ACCESS DESIGN REVIEW – STATE SIGNIFICANT DEVELOPMENT APPLICATION (SSDA)

Aldi Mixed Use Development

810 Pacific Highway, Gordon NSW 2065

Revision: ADR 1.1

DRAWING BY: AA, HK	CHECKED BY: KS	DATE: 17/12/2025
SCALE: 1:100@A1	DRAWING NO: DA100	ISSUE: A
PROJECT NO: 2432

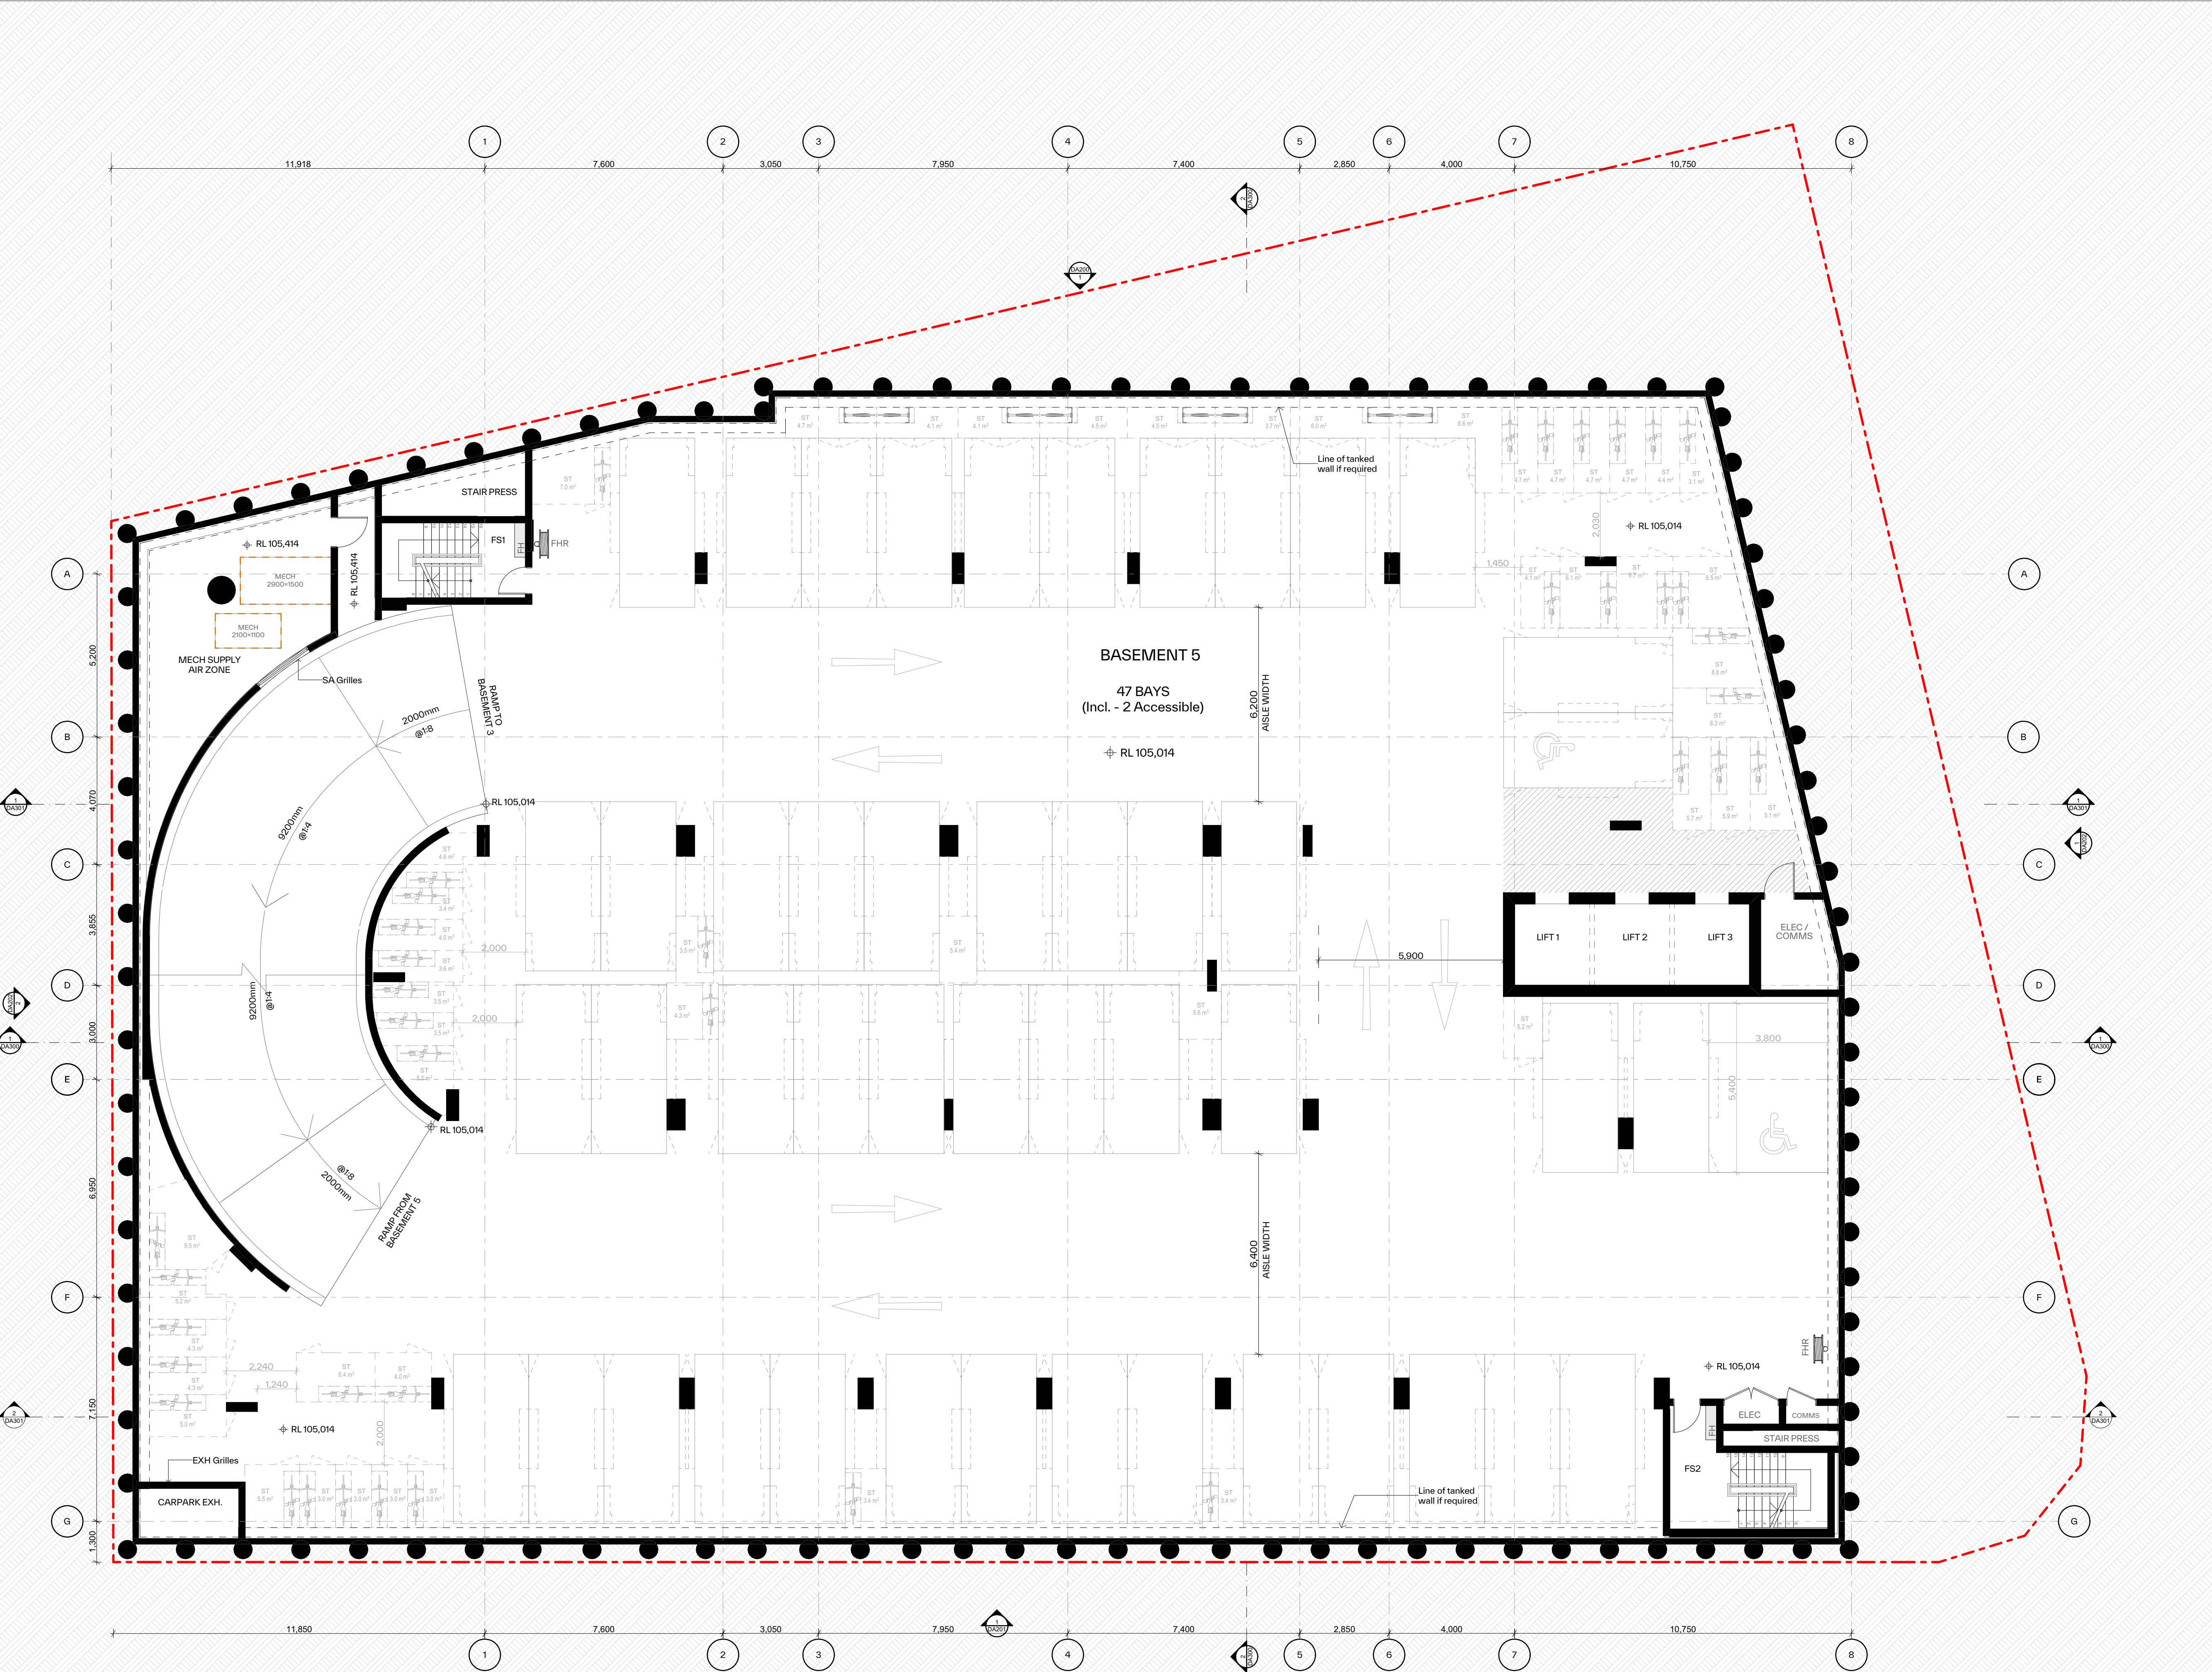
Item	BCA Clause	Relevant Performance Requirement	Technical Requirement	Technical Departure
1.	D4D6	D1P8	AS2890.6-2009 cl 2.2.1(b) requires a 2.4 metre car bay with 2.4 metre wide shared area	A structural column is proposed within the shared area of accessible carparking spaces on Basement 3 to 6. The encroachment is a departure from AS2890.6-2009 cl 2.2.1(b).
